Application no: 22/02692/DISC

Location: Heyford Park, Camp Road, Upper Heyford, Bicester, OX25 5HD

Transport Development Control

Condition 22: Objection

PROJECT NO: 001 DRAWING NO: PH10_TM001 REVISION: A

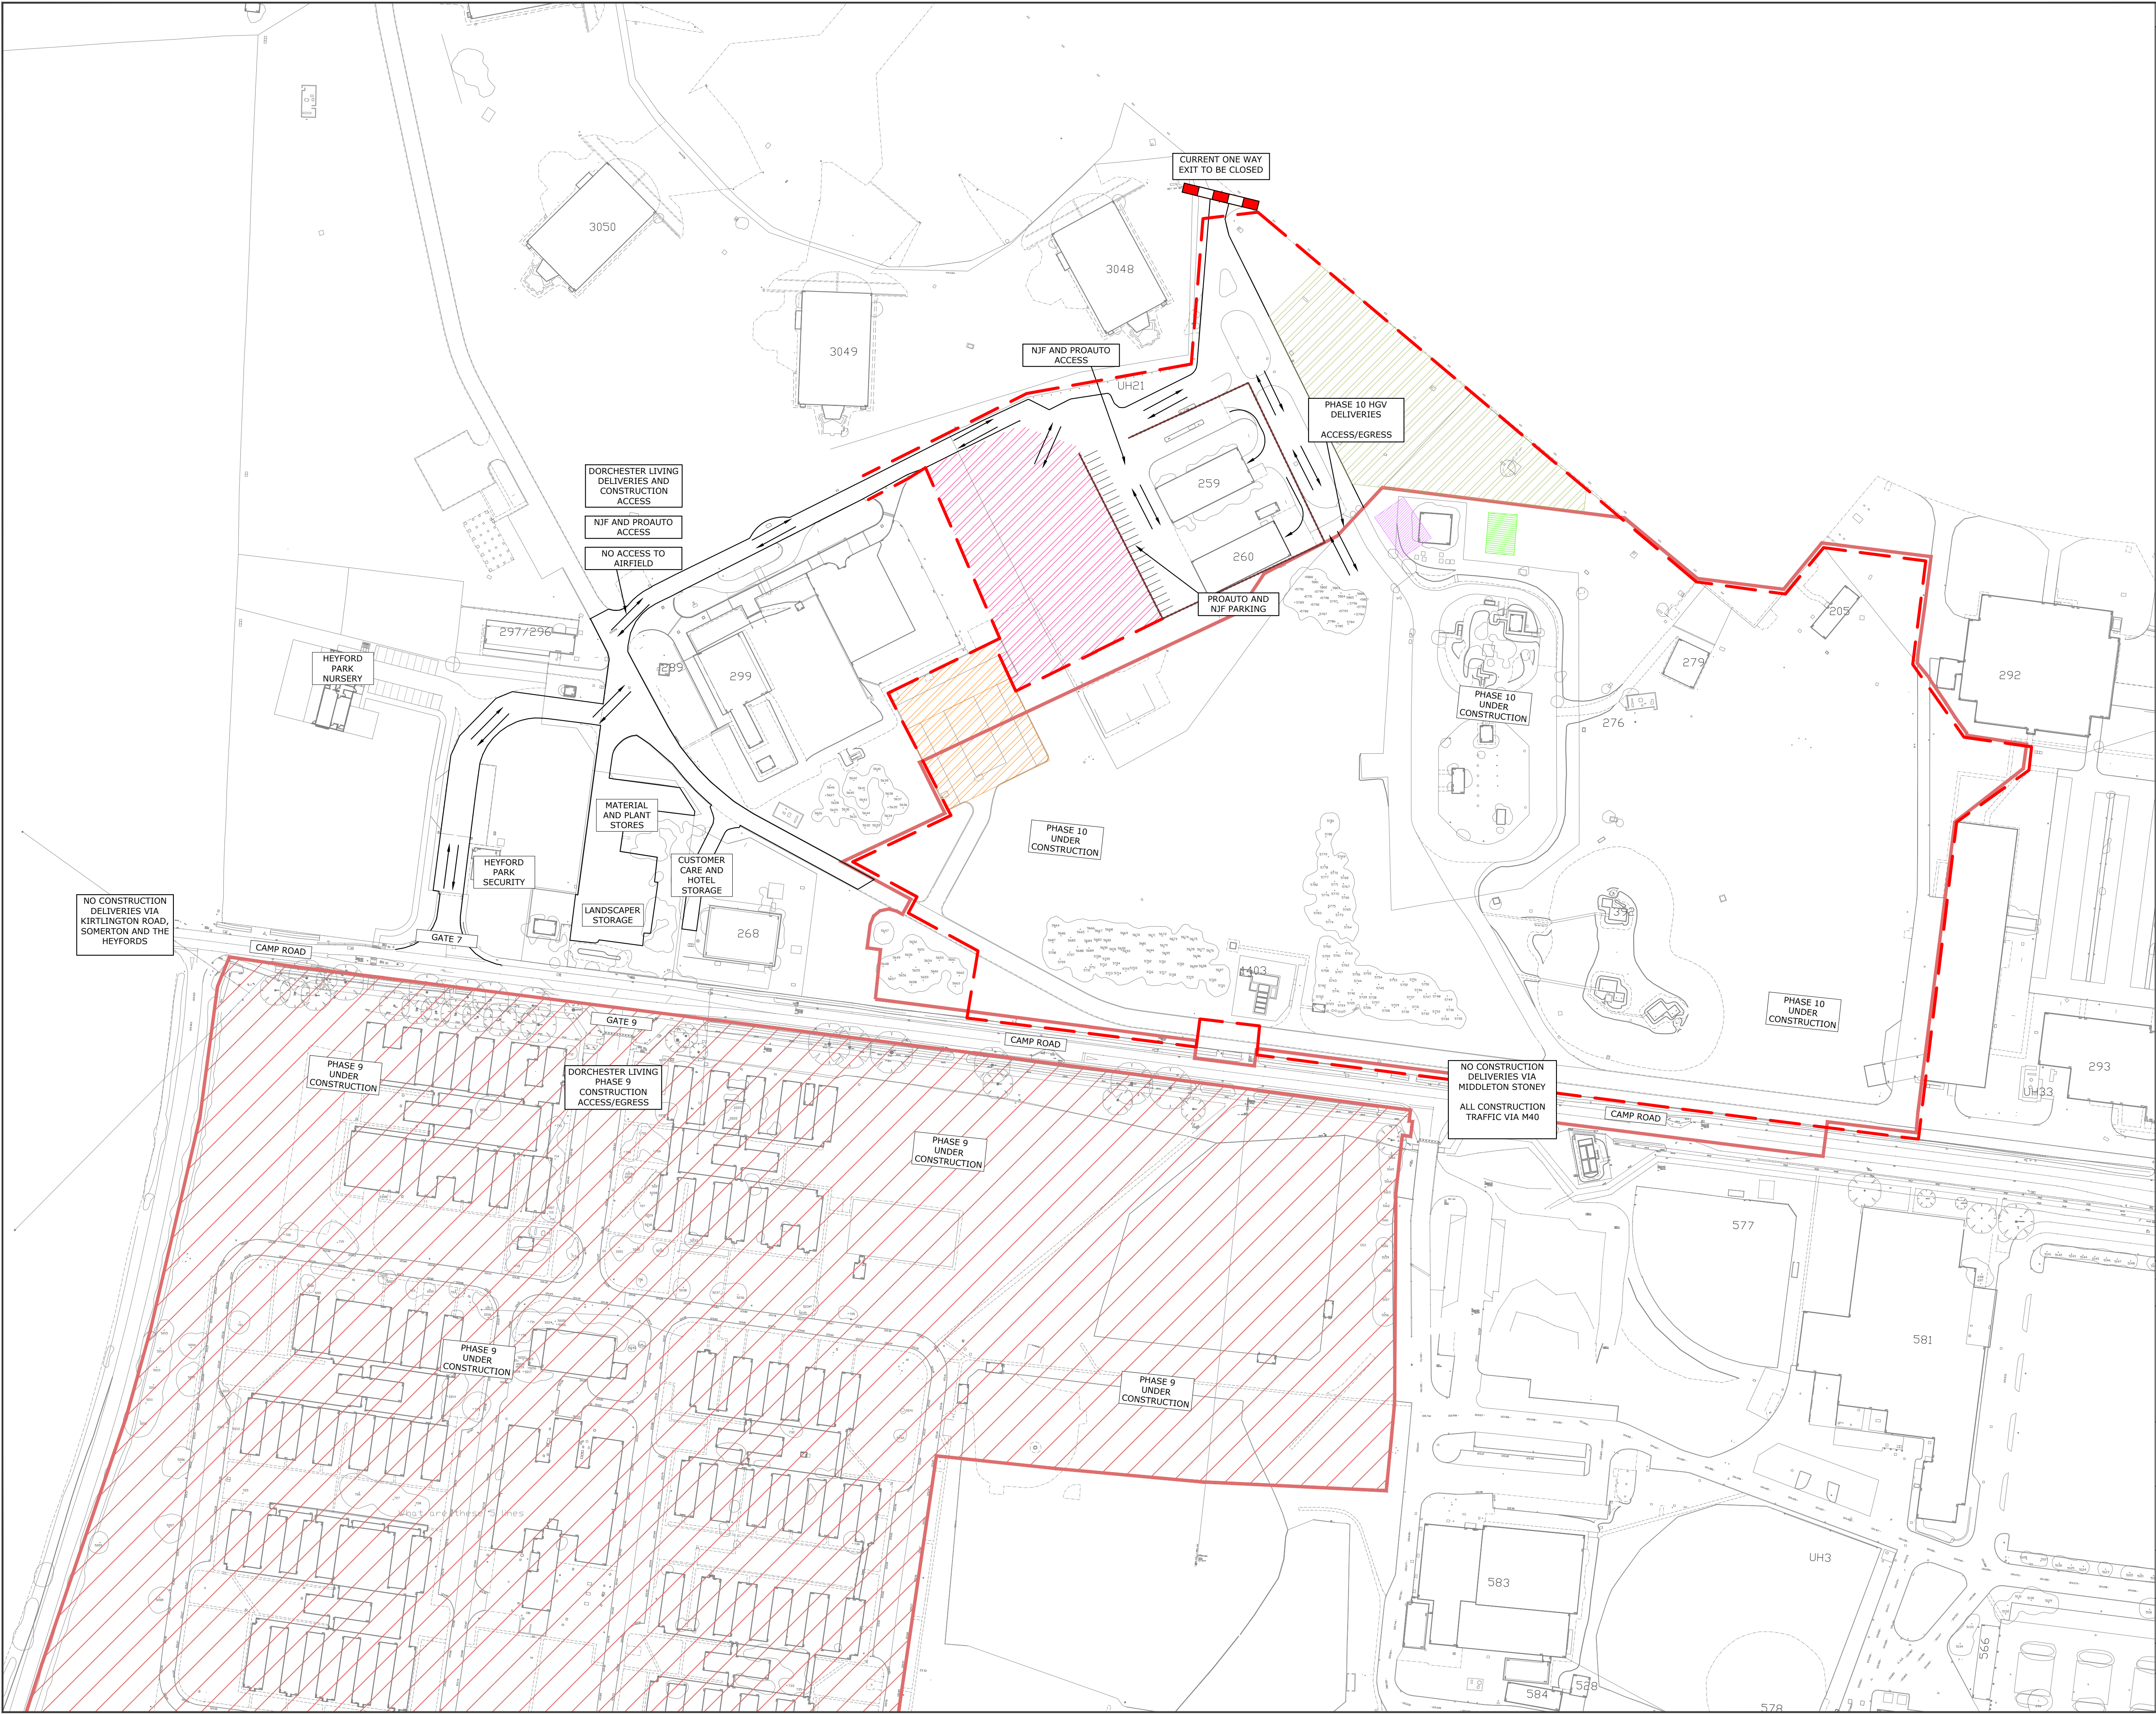
In order for Condition 22 to be discharged, the Construction Method Statement should be updated to show the following:

- Deliveries or movement of heavy construction vehicles should not occur between the hours of 07:30-09:30, 15:00-16:00 and 16:00-18:00. This is to avoid network peak hours and school pick up / drop off.
- Contact details of the Project Manager and Site Supervisor responsible for on-site works to be provided.
- A before-work commencement highway condition survey and agreement with a representative of the Highways Depot – contact 0845 310 1111. Final correspondence is required to be submitted.
- Local residents to be kept informed of significant deliveries and liaised with through the project. Contact details for person to whom issues should be raised with in first instance to be provided and a record kept of these and subsequent resolution
